CITY OF ALBUQUERQUE

August 8, 2023

**Re: Blue Cross Animal Clinic
1650 University Blvd. NE
30-Day Temporary Certificate of Occupancy
Transportation Development Final Inspection**
Architect's Stamp dated 11-19-21 (H15-D015B)
Certification dated 07-27-23

TRAFFIC CIRCULATION LAYOUT

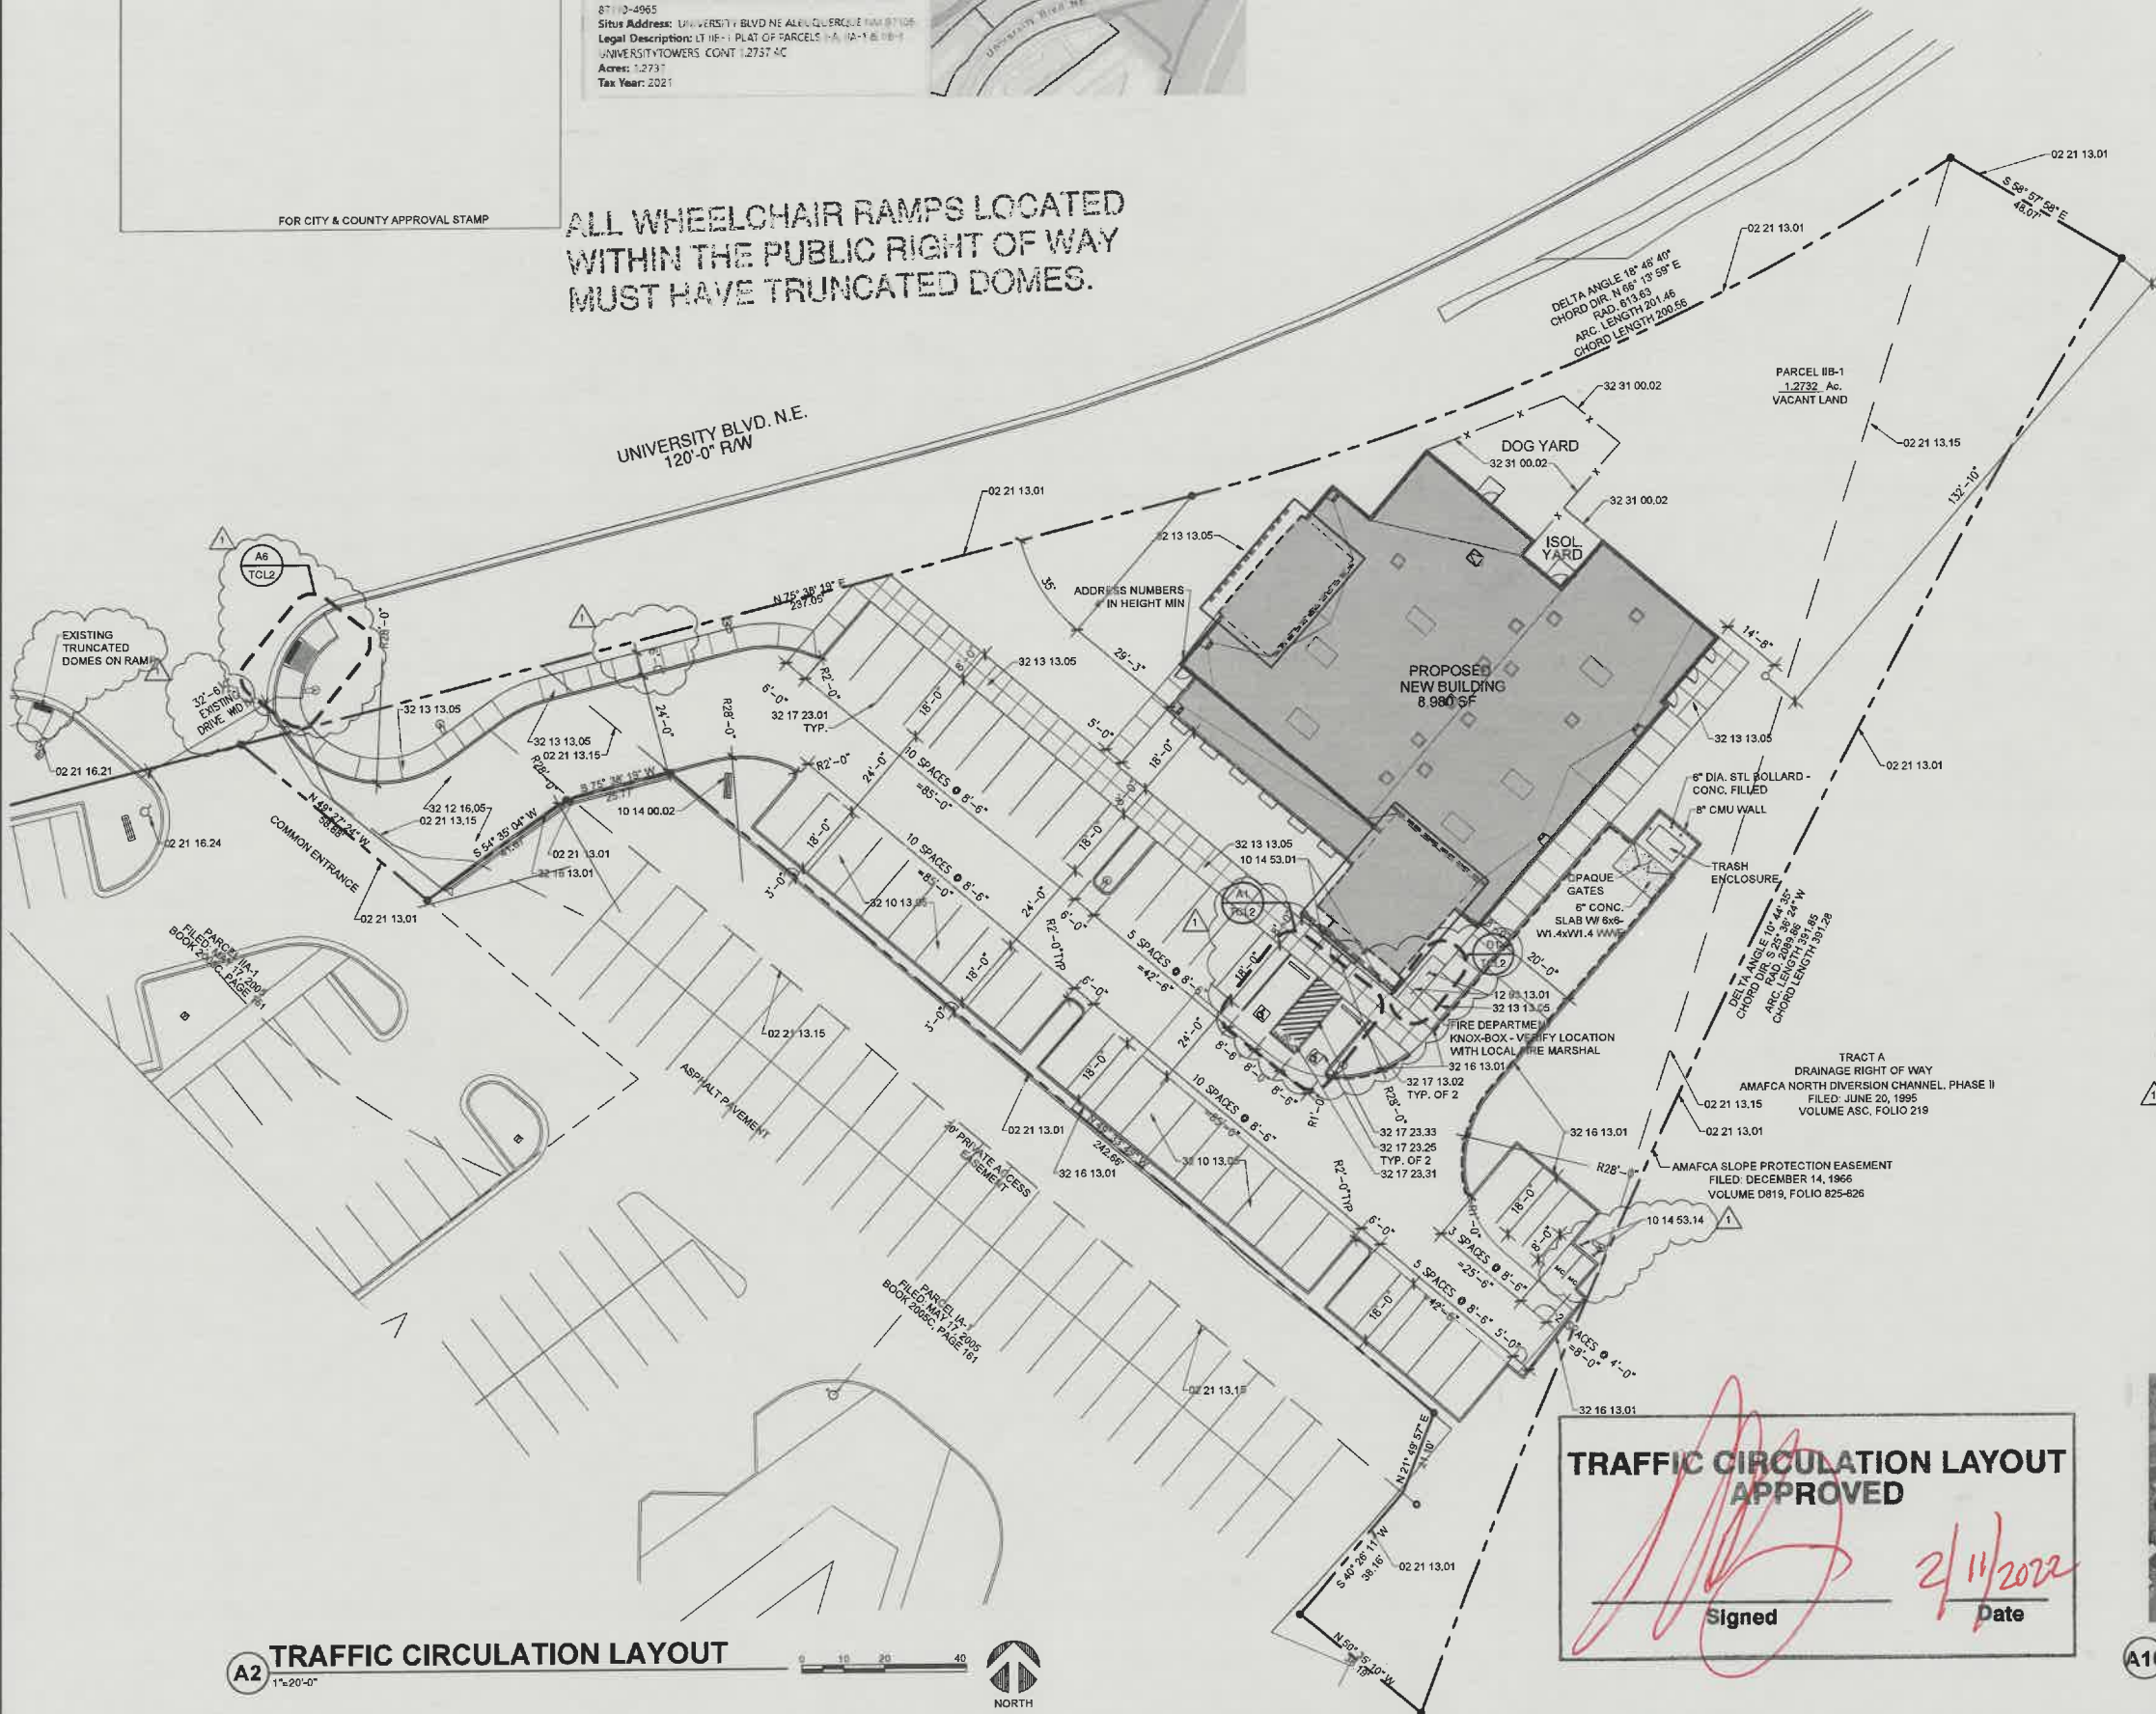
- Per approved plan, The pavement marking "MC" should be shown in the opposite direction for motorcycles entering the parking space.
